Addendum 01

To: All Select Bidding General Contractors and Registered Plan Holders
From: Ben Walter, CWS Architects
Regarding: **Logan Place SRO Apartment – Bidding Documents**
Subject: **Addendum 01**

The following addendum items apply to the project known as the **Logan Place** located in Portland, Maine.

**1 EXTERIOR ARCHED ENTRY DETAIL**  
SCALE: 1 1/2" = 1'-0"

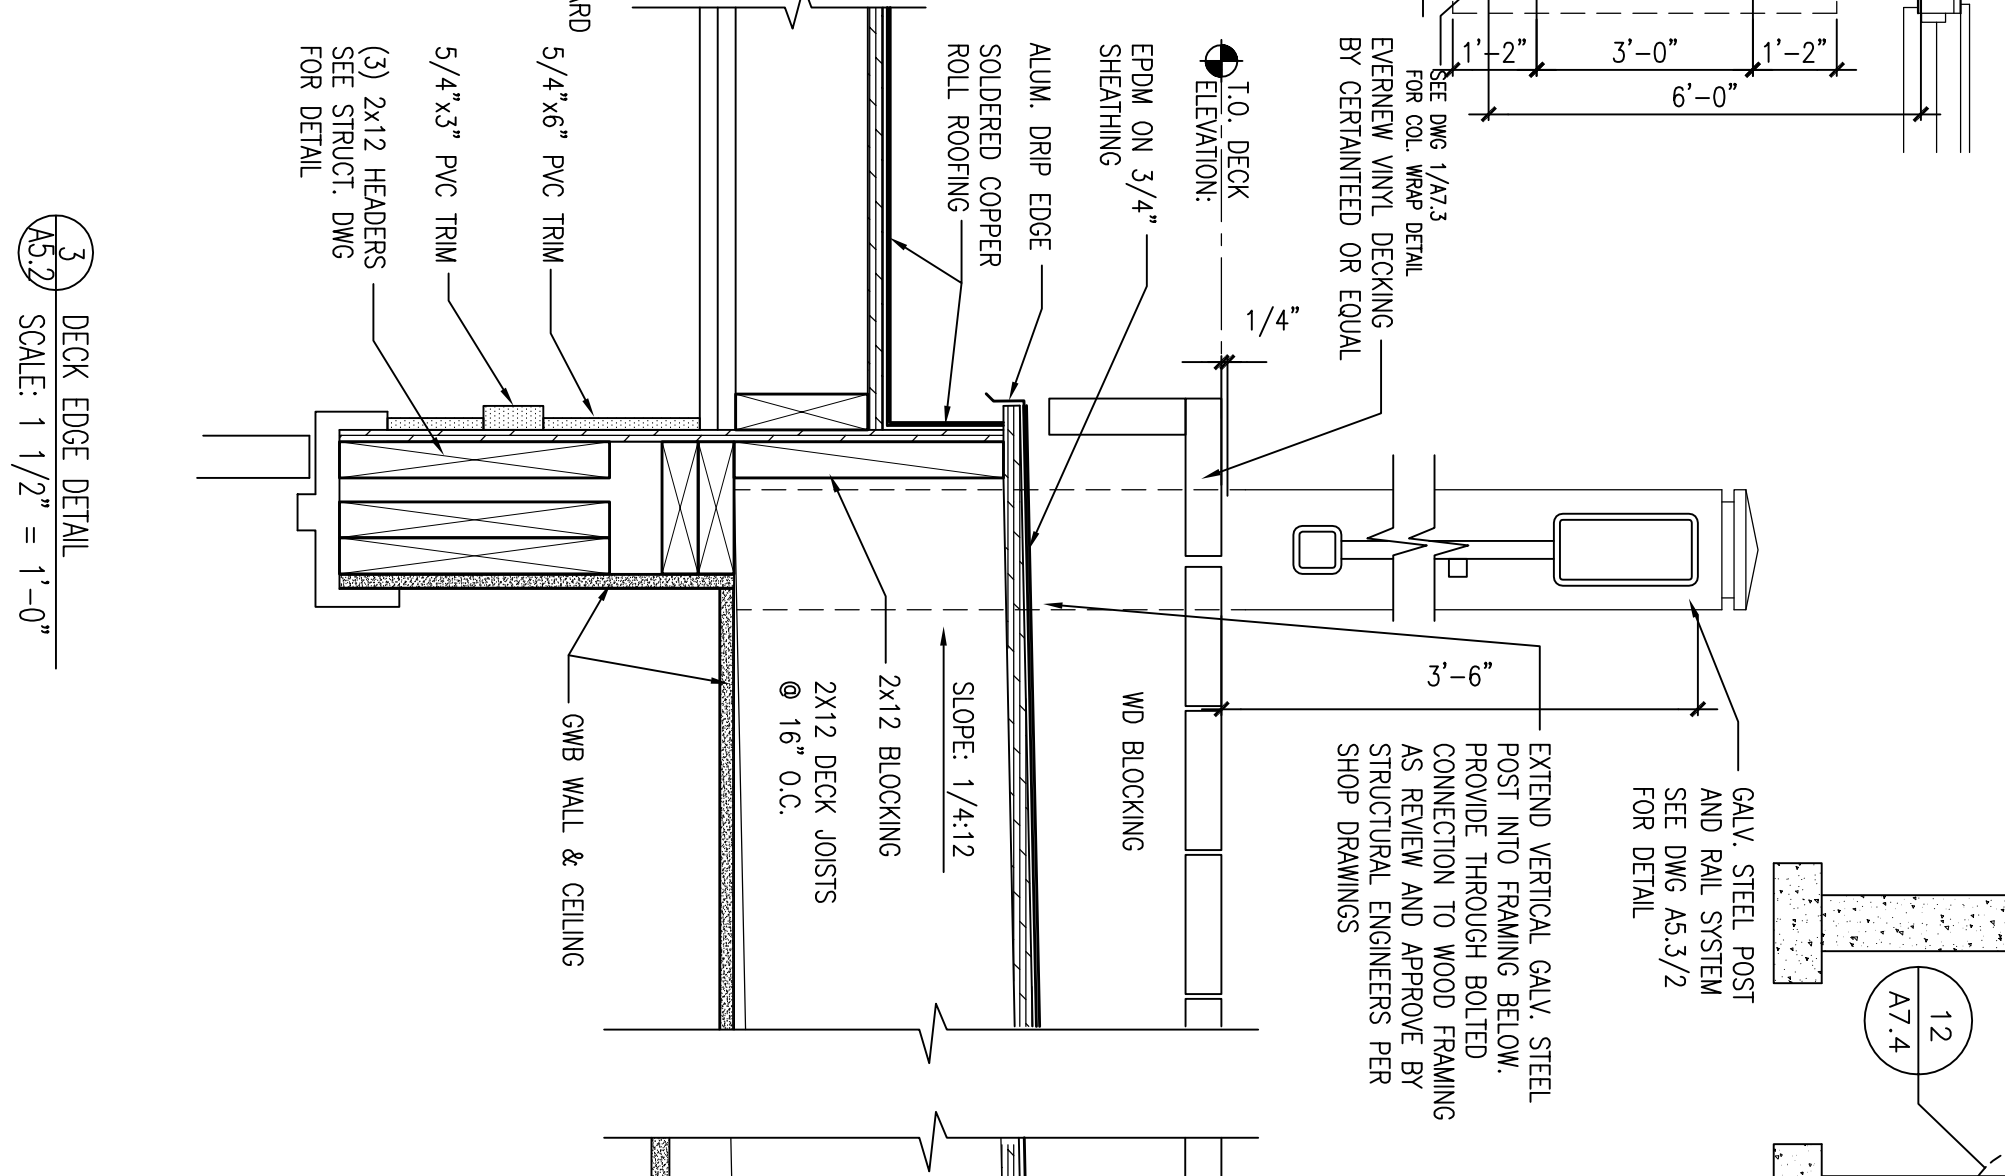
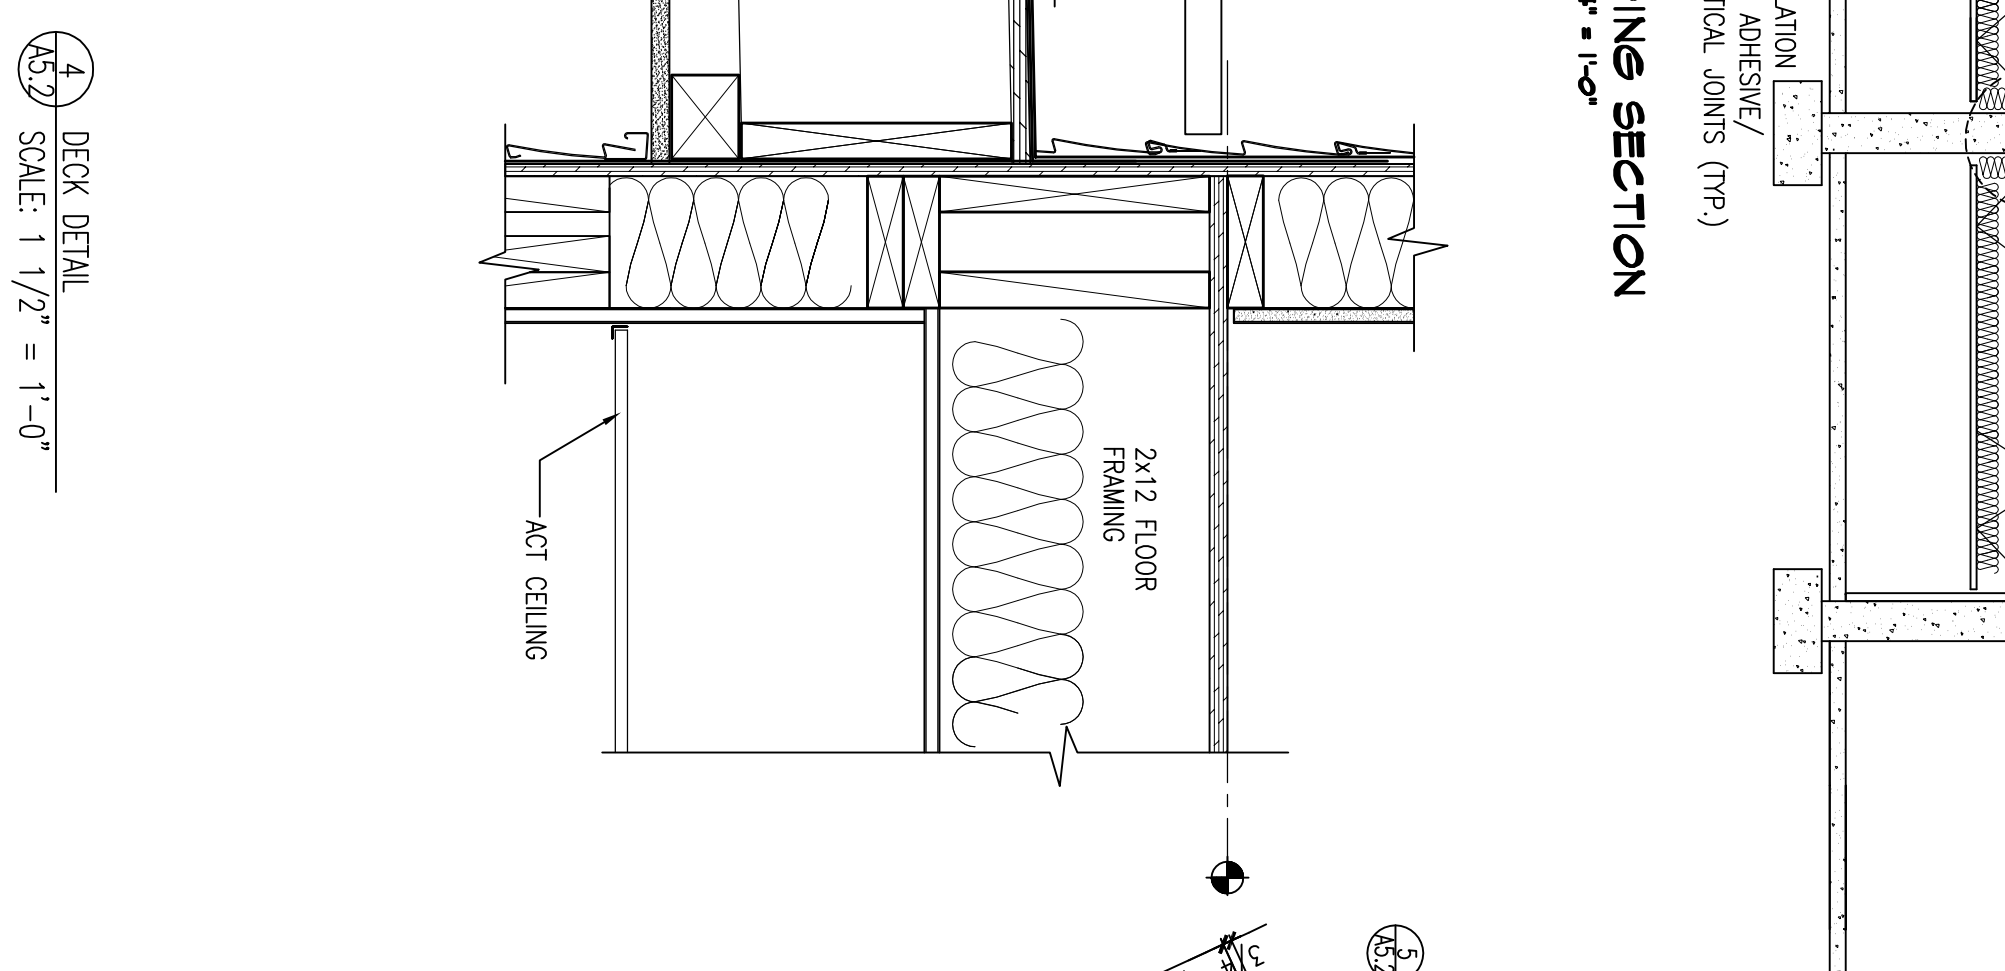
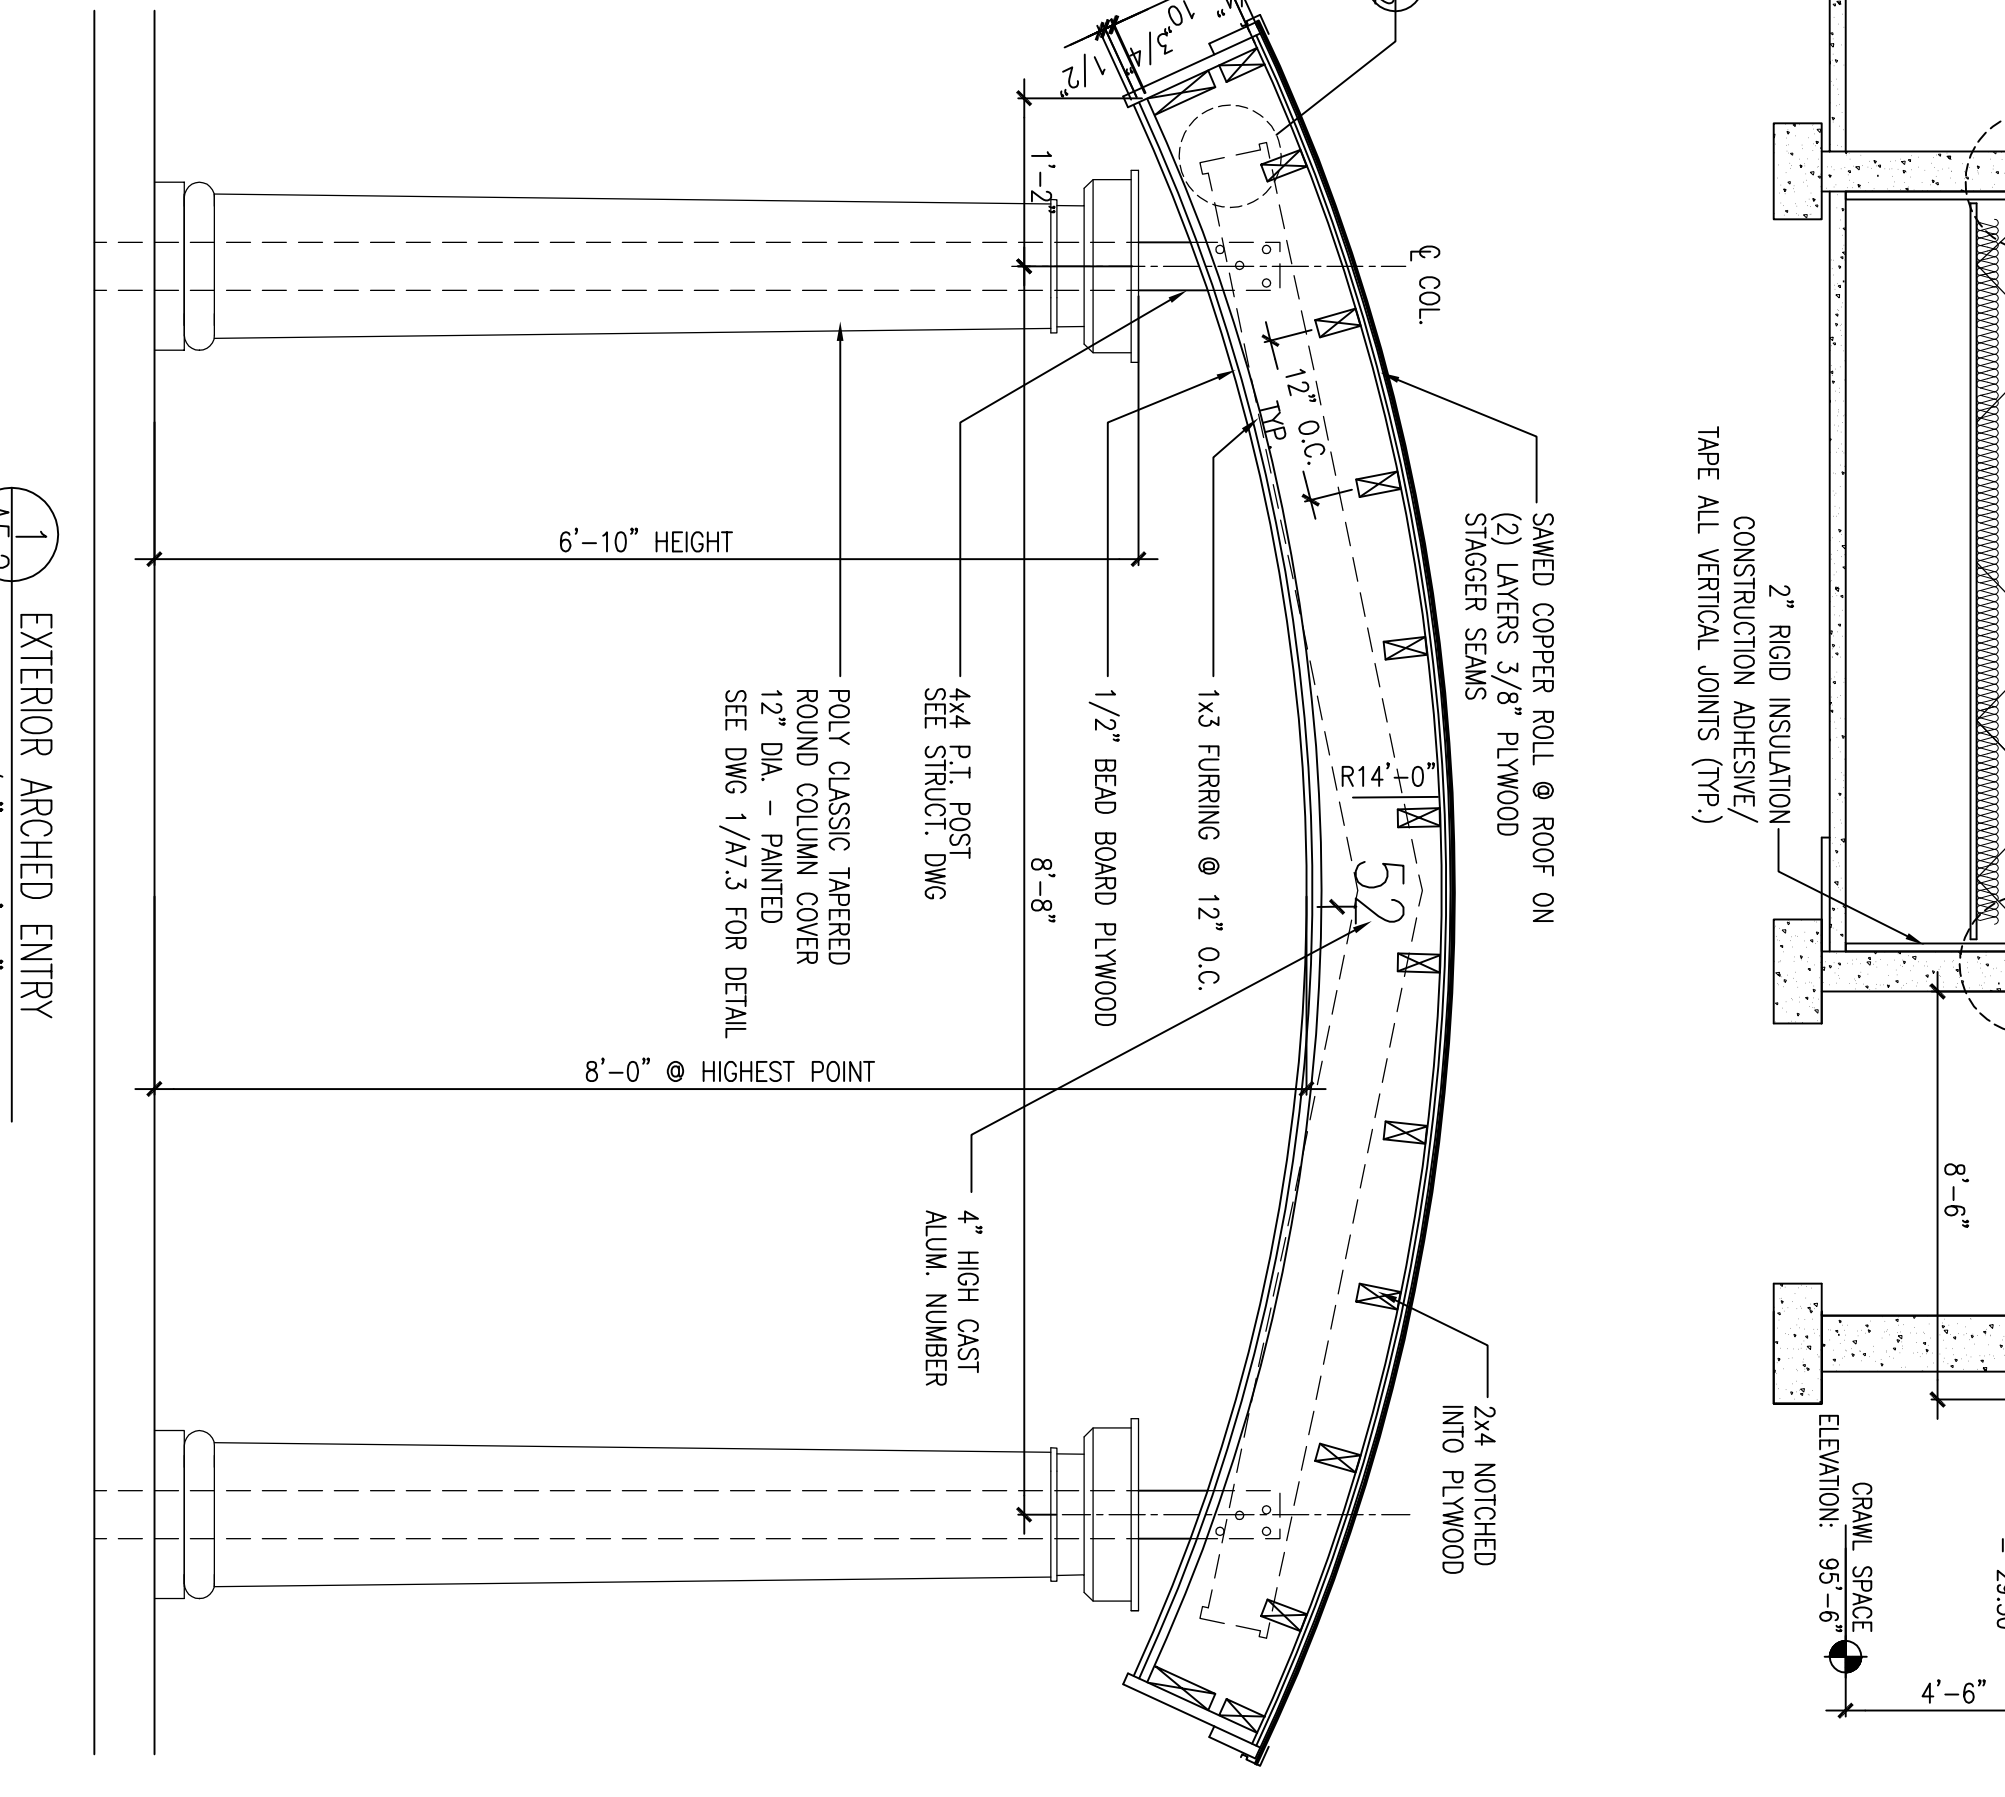
18. Modify all drawings Title Border: Change YC Portland L.P. address to 307 Cumberland Ave. Portland, Maine 04101.
 19. Clarification: Provide Poly-Classic Tapered Round – Plain Fiberglass columns by Brosco or equal at exterior locations where indicated. Refer to drawing A5.2 for columns size.
